Your ref:
Our ref: 23/00777/F
Please ask for: Amy Davies
Direct dial: 01553 616879
E-mail: borough.planning@west-norfolk.gov.uk

24 May 2023

Details: **Extension and alterations to bungalow at Rose Bungalow Hubbards Drove
Hilgay Norfolk PE38 0JZ**

PROPOSED LAYOUT

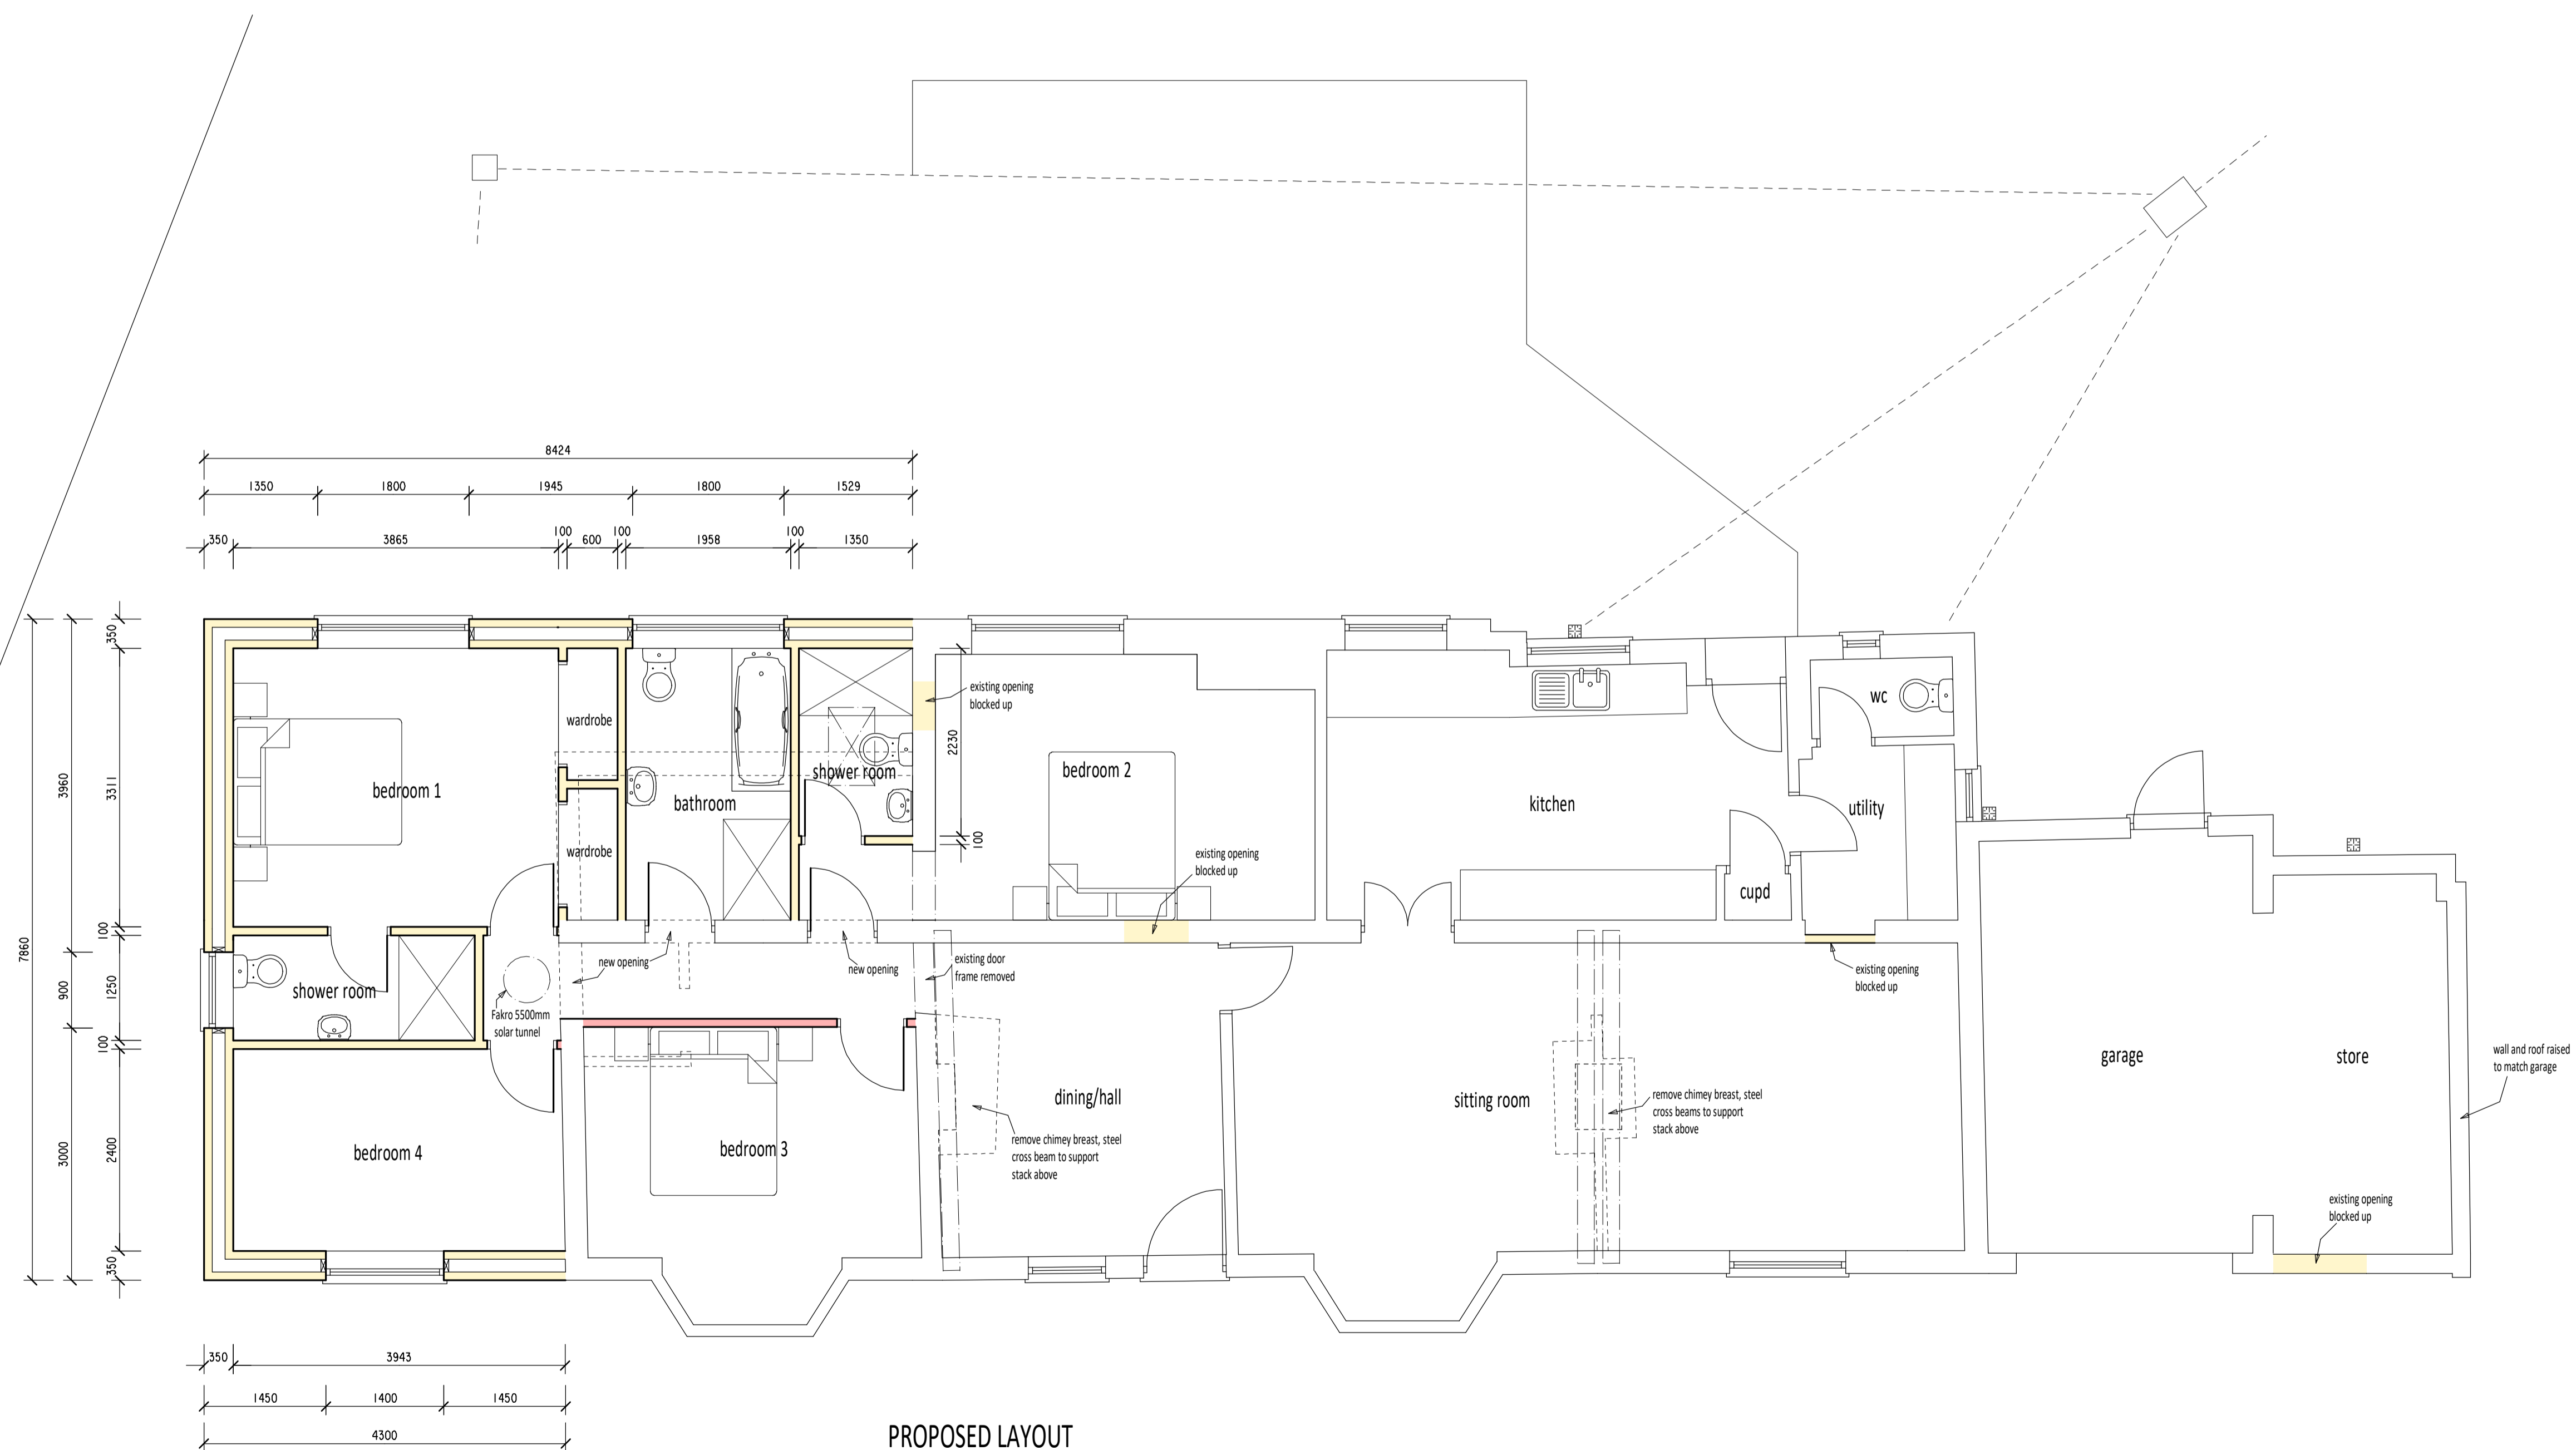
1. It appears on the floor plan on the north side is showing a window in bedroom 2 but does not appear to be showing on the north elevation.
